Re: Status of Improvement Permit Application #07-5-18772 & #07-5-18774
Pope Lake

On November 5, 2007, an attempt was made to evaluate your property for the purpose of issuing an Improvement Permit. The evaluation could not be completed for one or more of the following reasons.

**POPE'S LANDING  
 PHASE I**

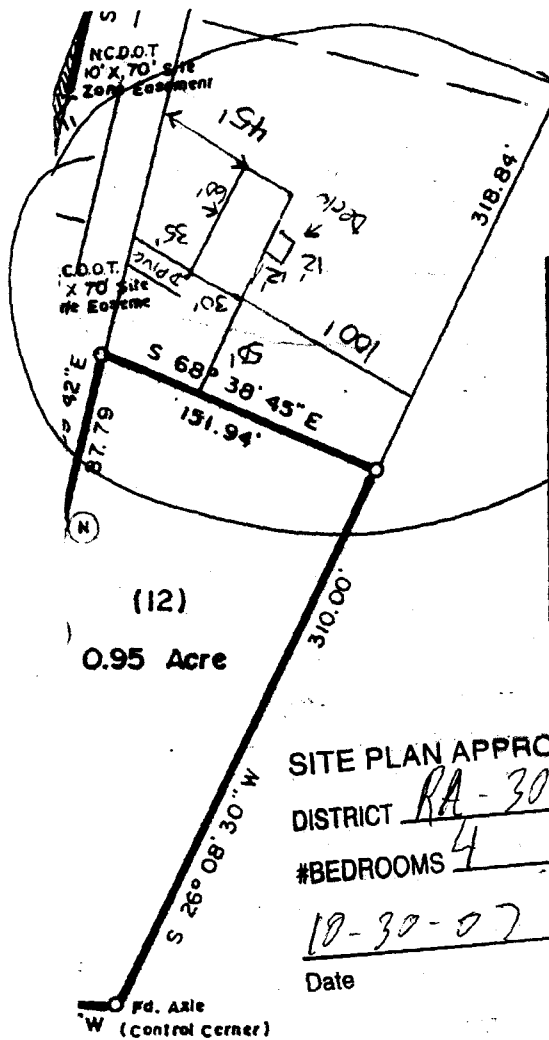
Lot 3 needs a revision to site plan to change front property line from 45 feet to 36 feet. Lot 2 needs a new map that matches the property.
